January 11, 2018

Subject: Request for Modification to the Section 404 Individual Permit and Section 401 Water Quality Certification for the proposed Greensboro Western Loop from north of SR 2176 (Bryan Boulevard) to SR 2303 (Lawndale Drive), Guilford County, Division 7. Federal Aid Project No. STP-NHF-124(1), WBS Element No. 34820.3.30, TIP No. U-2524C and D.

The purpose of this letter is to request a modification to the United States Army Corps of Engineers (USACE) Section 404 Individual Permit and North Carolina Division of Water Resources (NCDWR) Section 401 Certification for the above referenced project.

PERMIT DRAWINGS  
 SHEET 12 OF 25

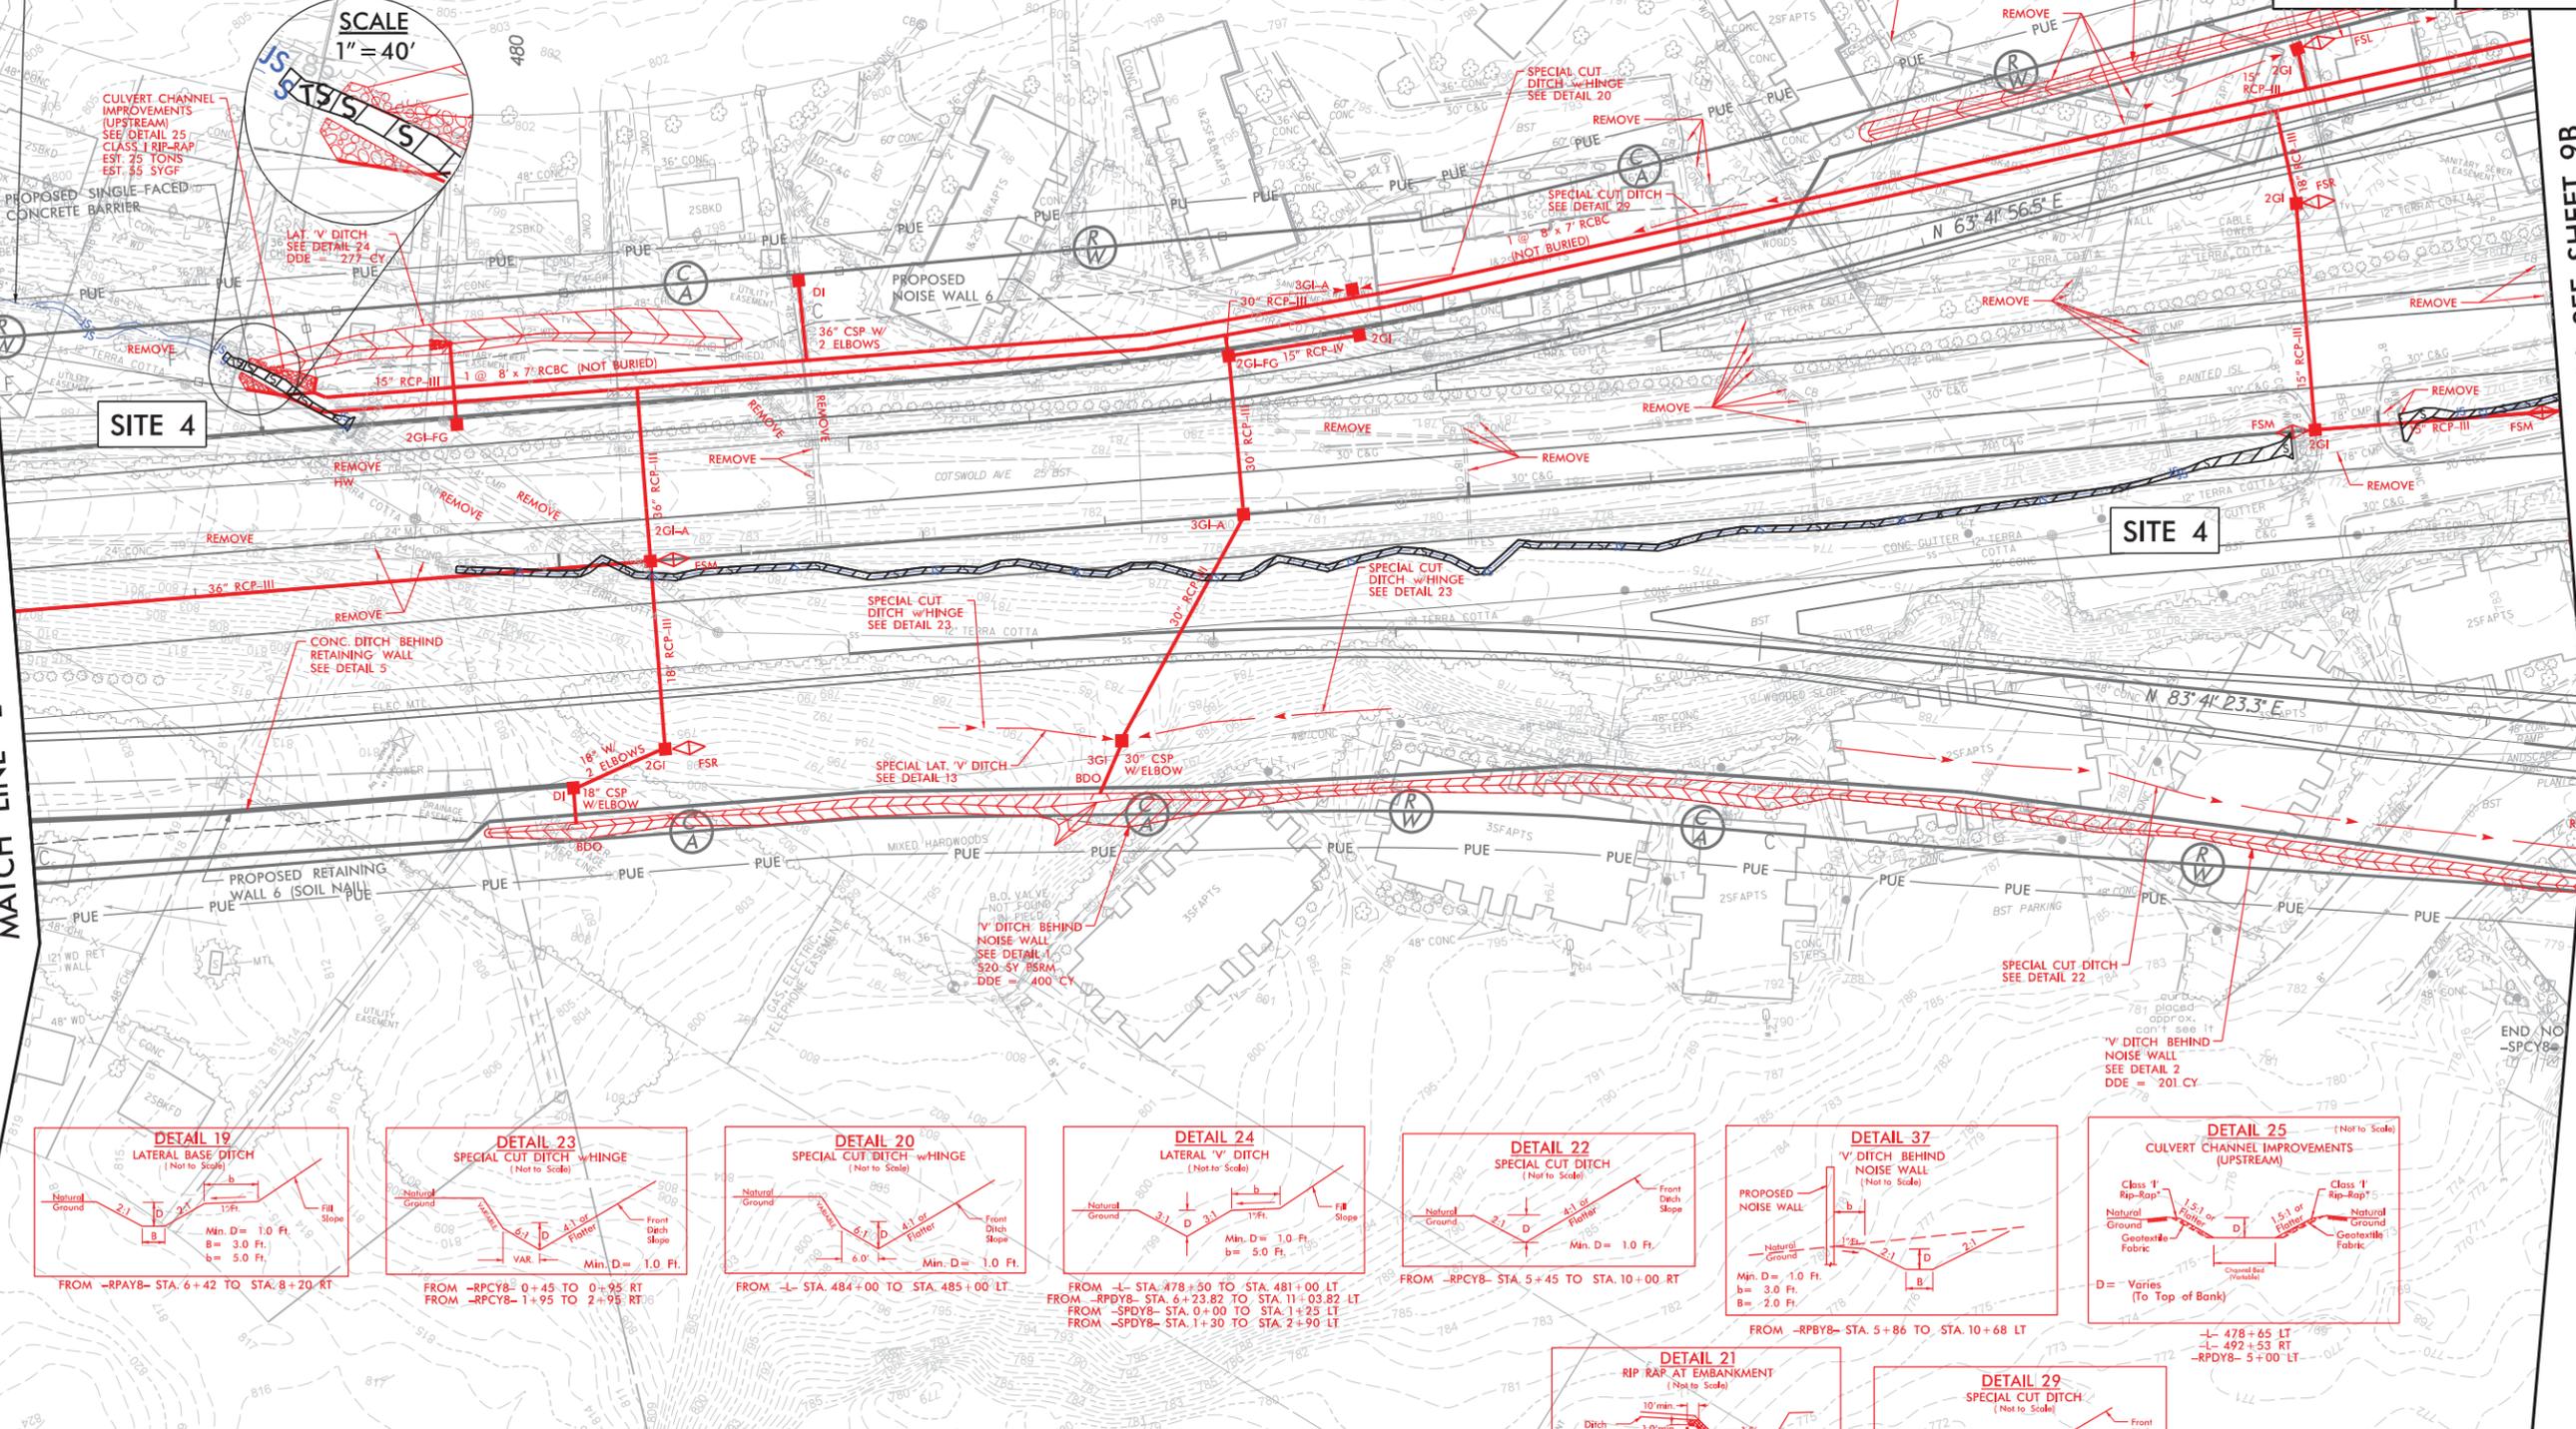
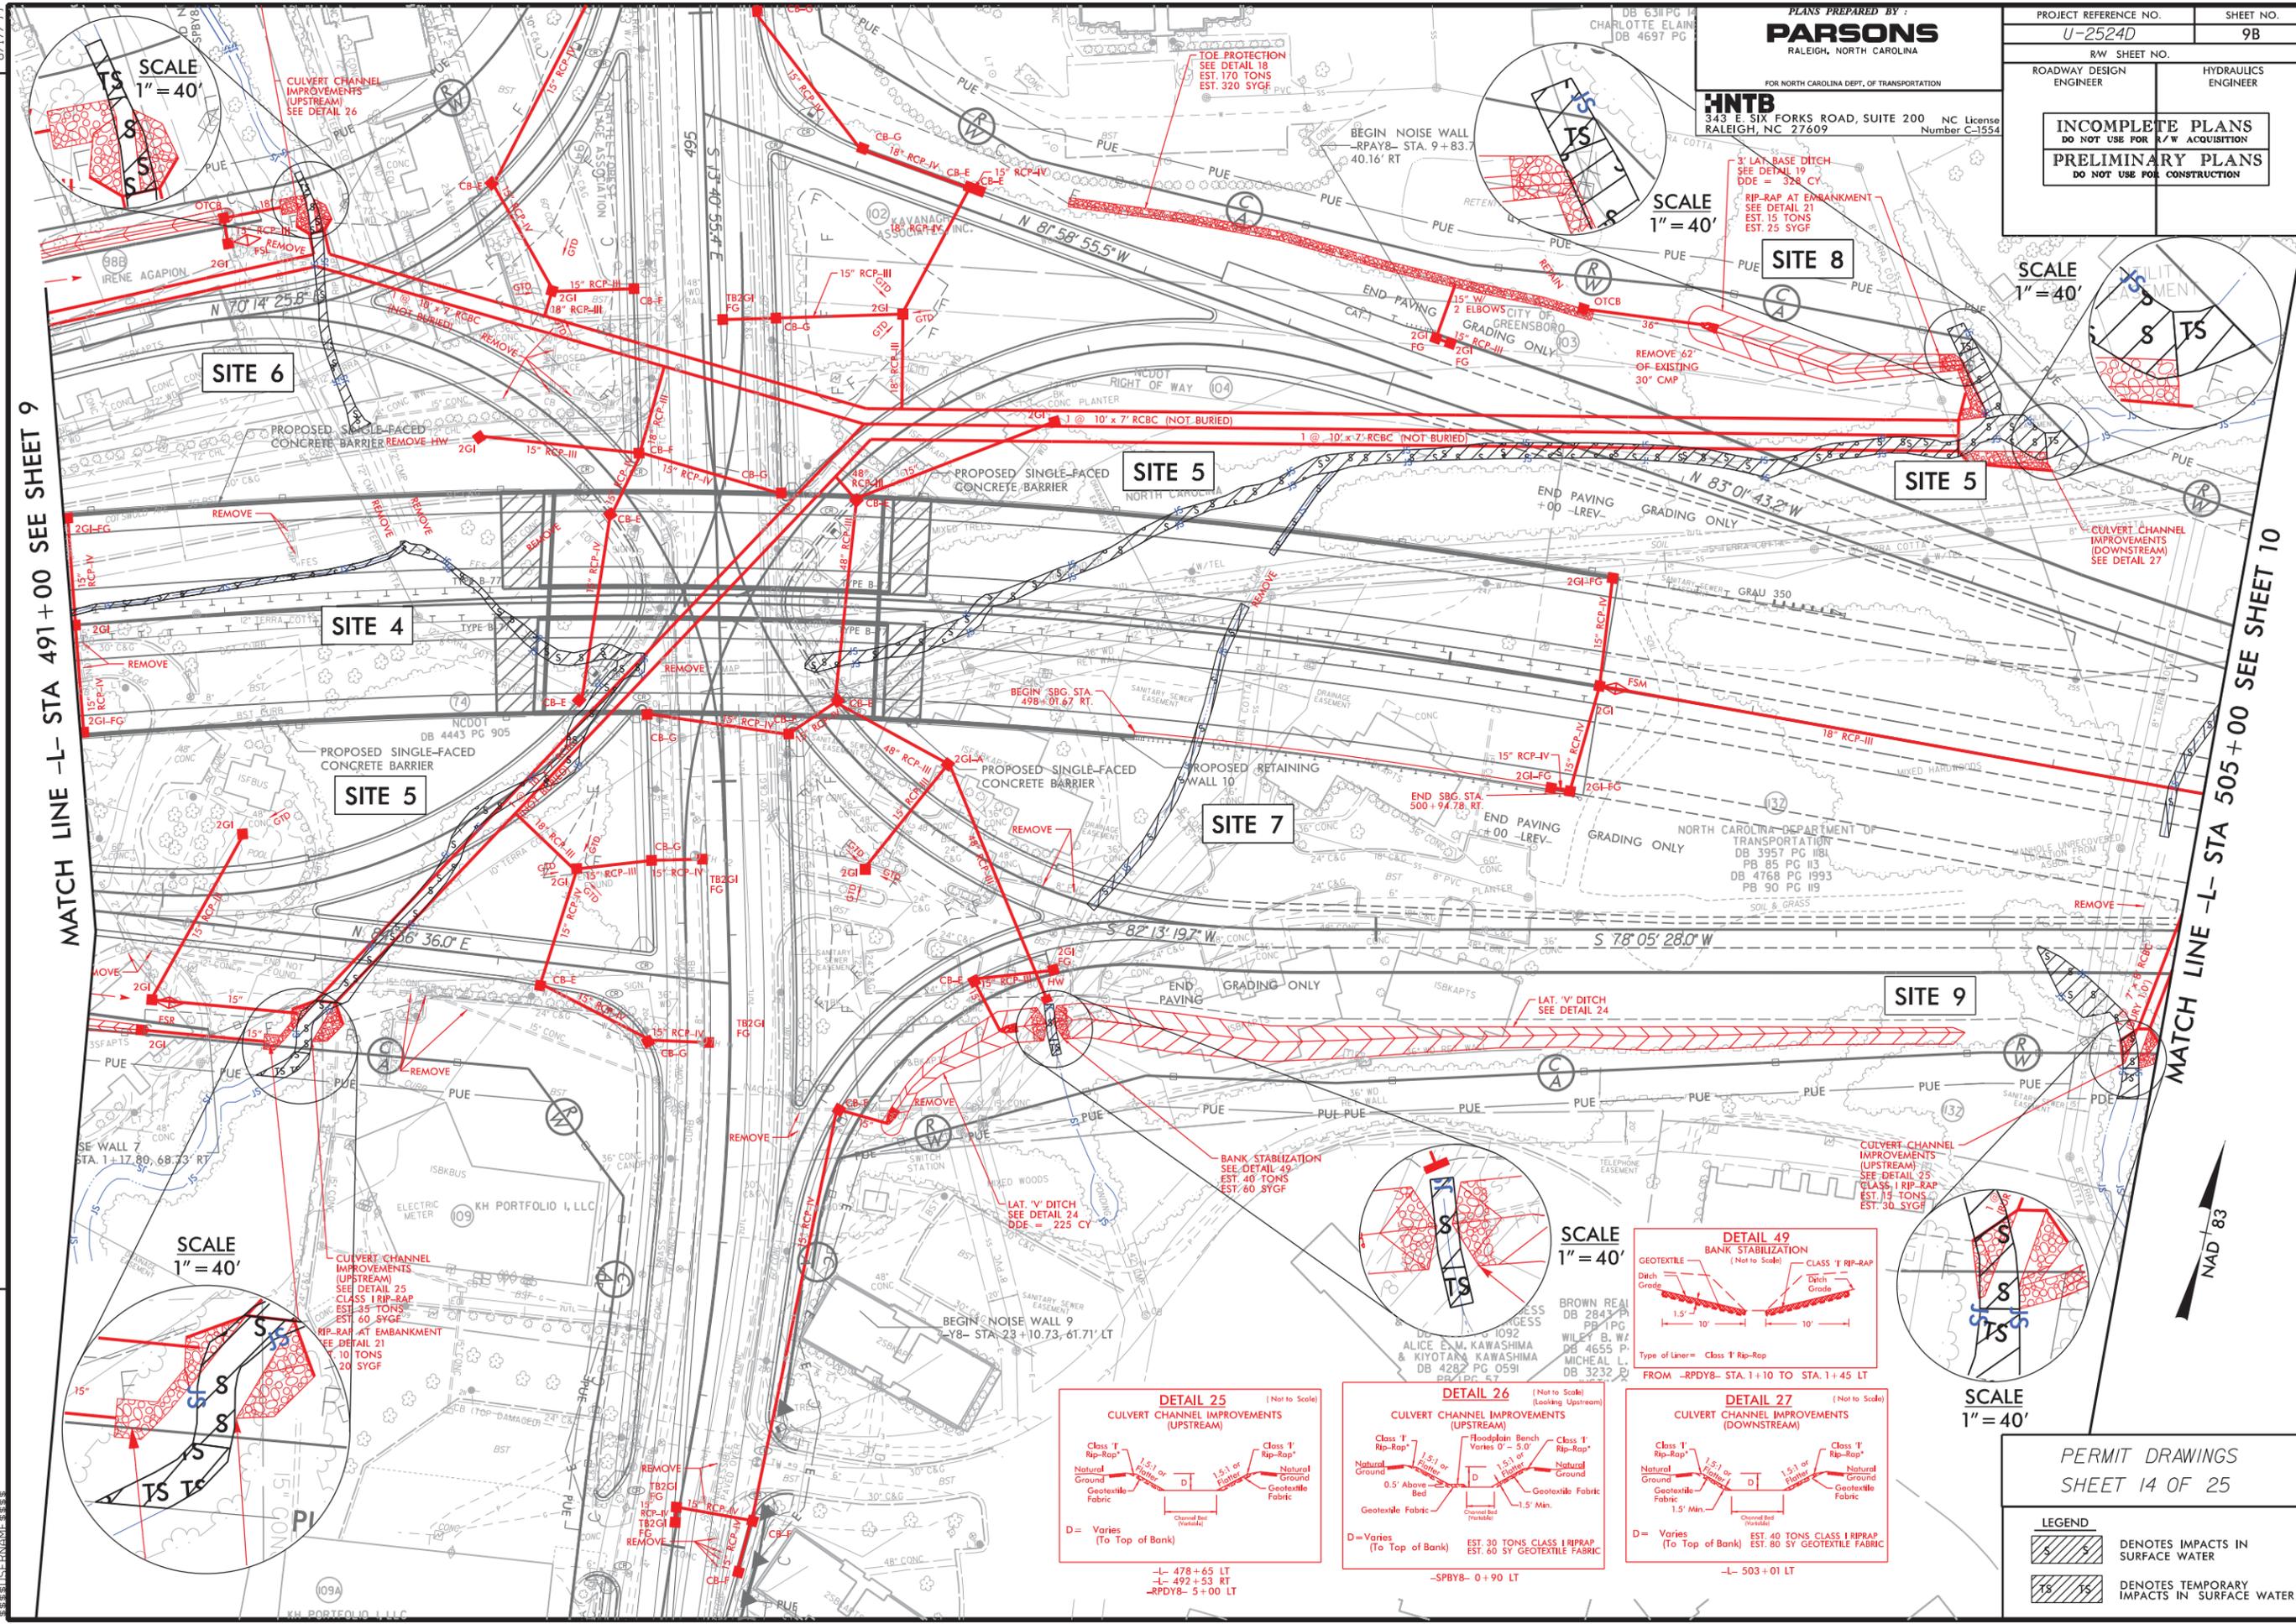
Since construction of the culvert at U-2524D, Permit Site 4, the portion of stream SV upstream of the culvert has experienced channel instability and erosion issues. In order to armor against further bank erosion, the Department is proposing to install an additional 70 linear feet of bank stabilization with Class I riprap and install a series of grade controls (rock steps) in this area.

Please see the enclosed revised permit sheets 11, 12 and 25 (of 25) as well as the new permit sheet 12a detailing the grade controls. No additional mitigation is required for the modified impacts (confirmed with USACE and NCDWR in December 2018).

This would mean that the revised total impacts at U-2524D Permit Site 4 would include 1,581 linear feet (lf) of permanent fill, 70 lf of stream bank stabilization including addition of grade controls, and <0.01 acre of temporary impacts.
